CITY OF ALBUQUERQUE

**Re: Fountain Hills Drainage Management Plan
Engineer's Stamp dated 6-4-07, (C12/D3B)**

FOUNTAIN HILLS
GRADING & DRAINAGE MANAGEMENT PLAN
PROPOSED BASIN MAP
ALBUQUERQUE, NEW MEXICO
JUNE, 2007

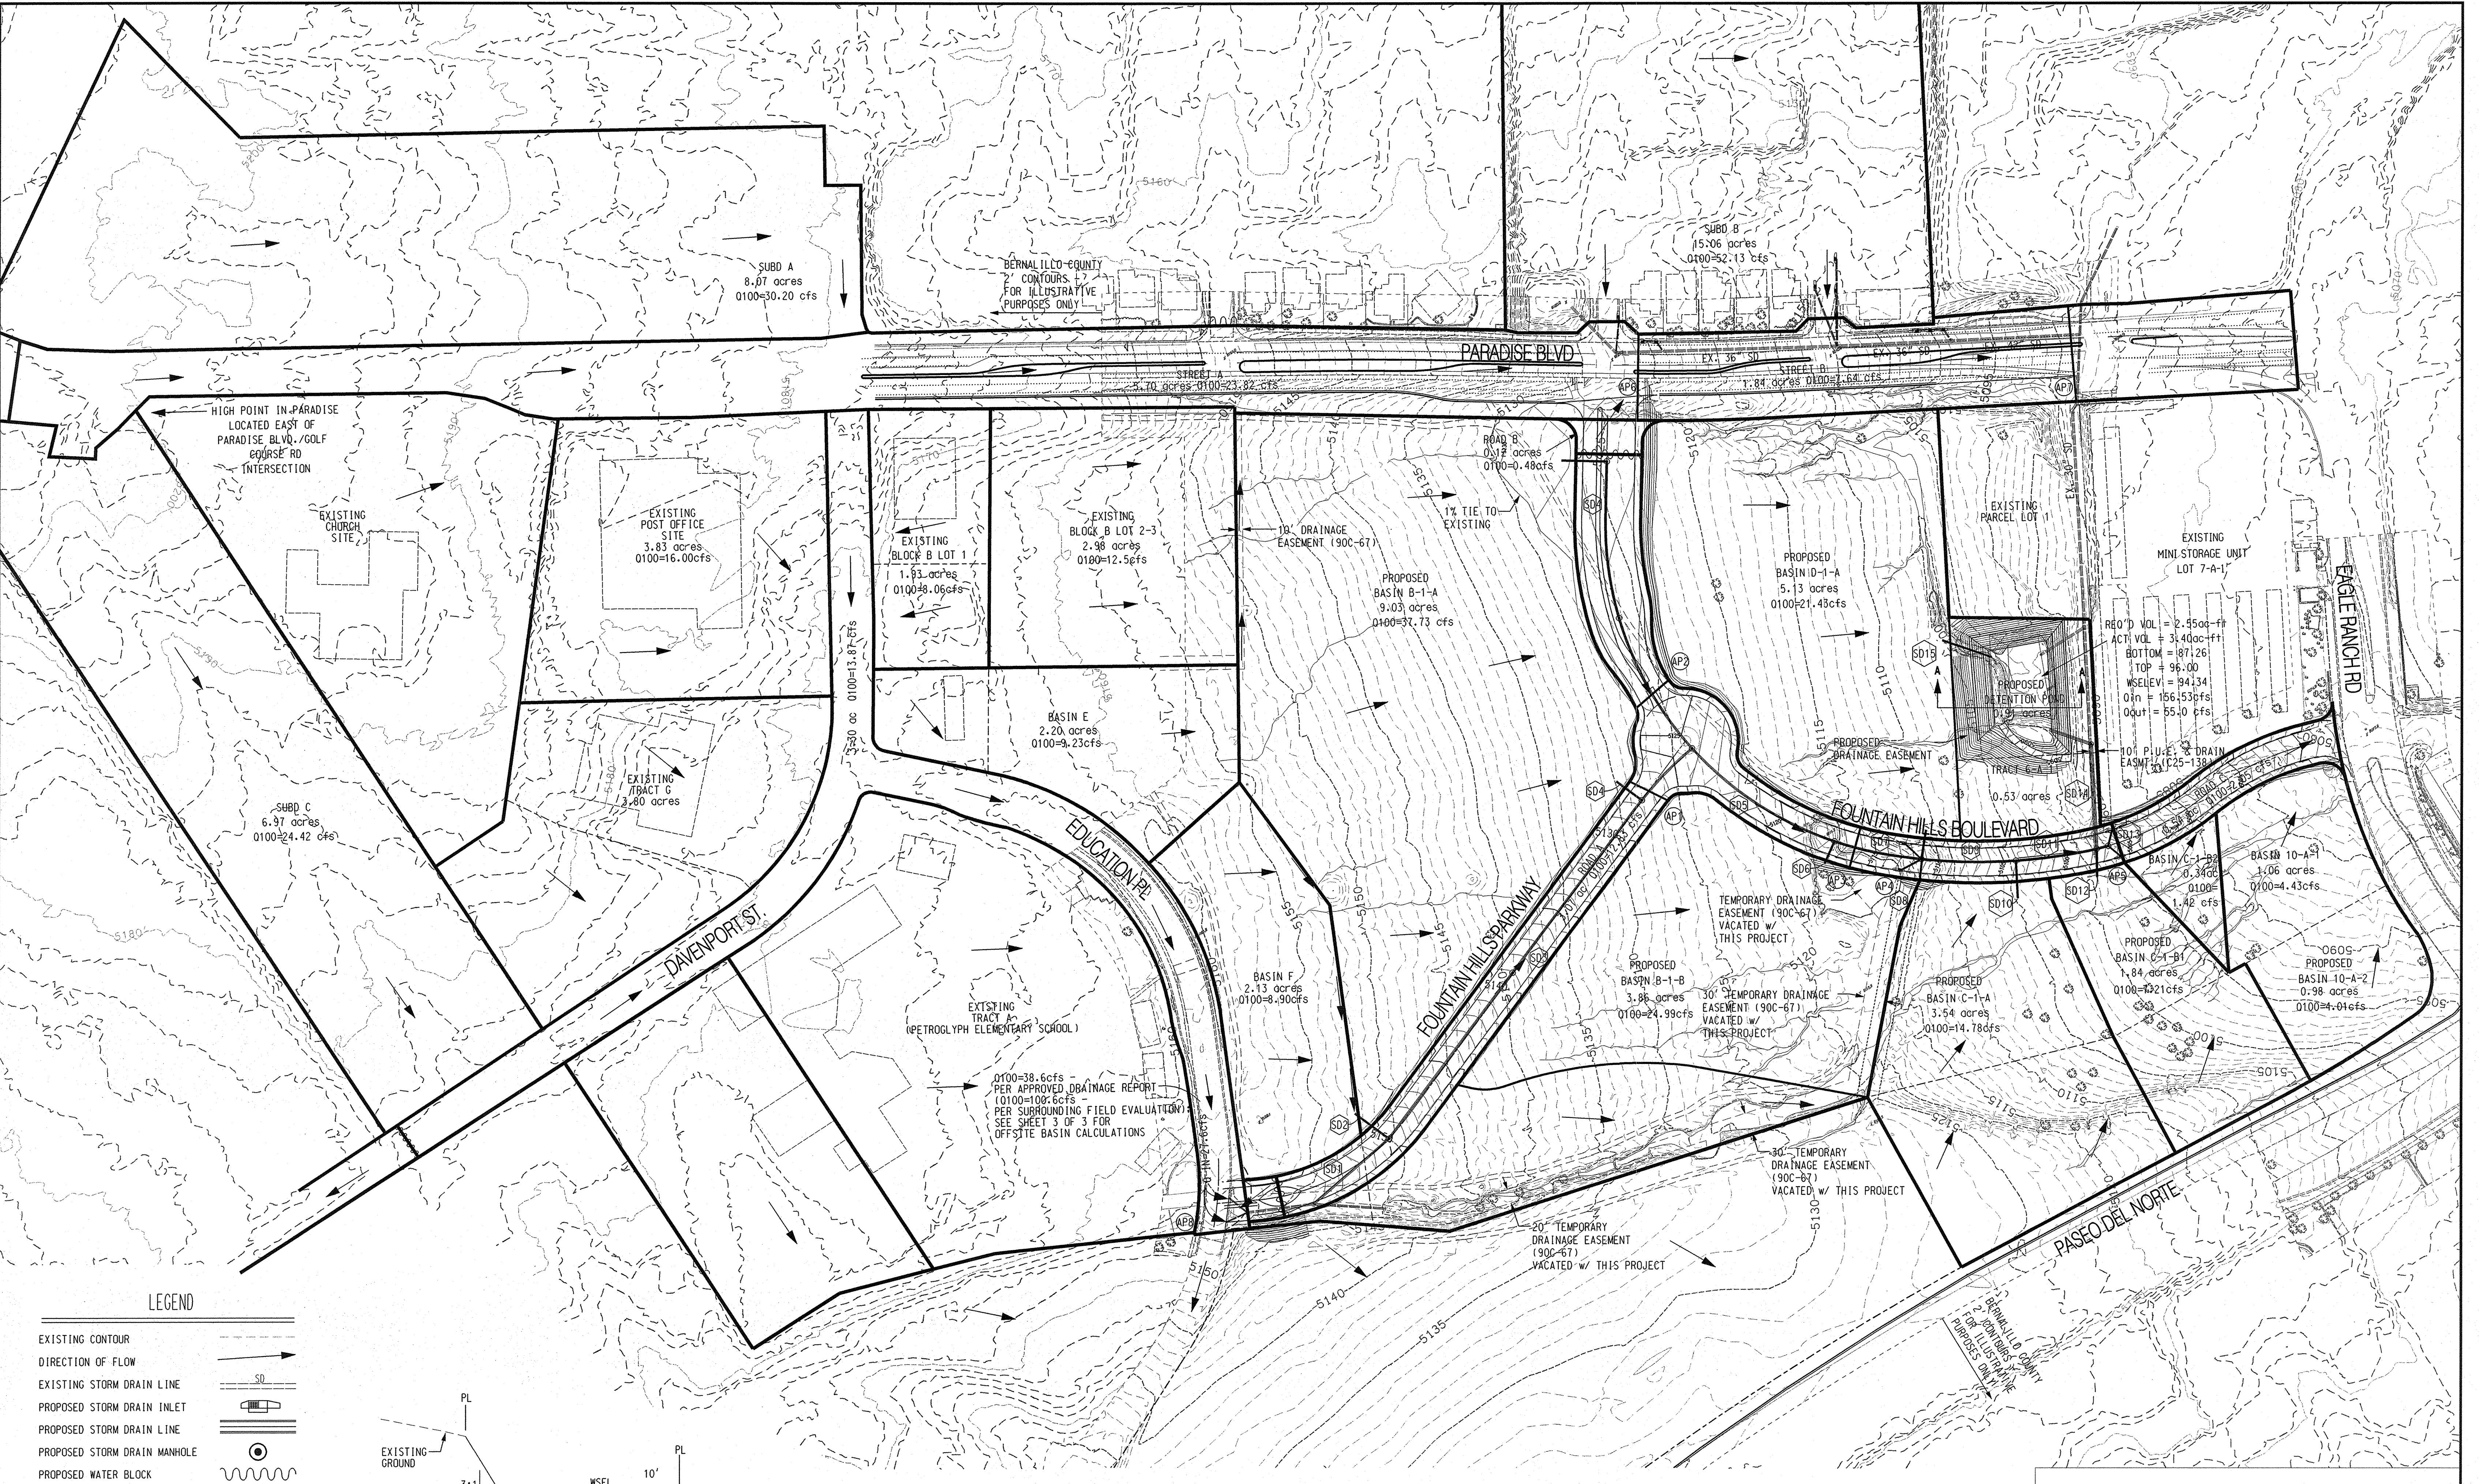
- The developed portion of Basin E drains to Education Place and the rest will drain through Basin F to SD2. Please update sheets 2 and 3 accordingly.
- The church site on Paradise does not drain to the post office. There is a pond on the south corner that retains a portion of the property.

- Since you will be modifying the inlets on Education Place with the construction of Fountain Hills Parkway, please provide enough inlet capacity to get as much as possible the 38.6 cfs allowed in the Fountain Hills storm drain.
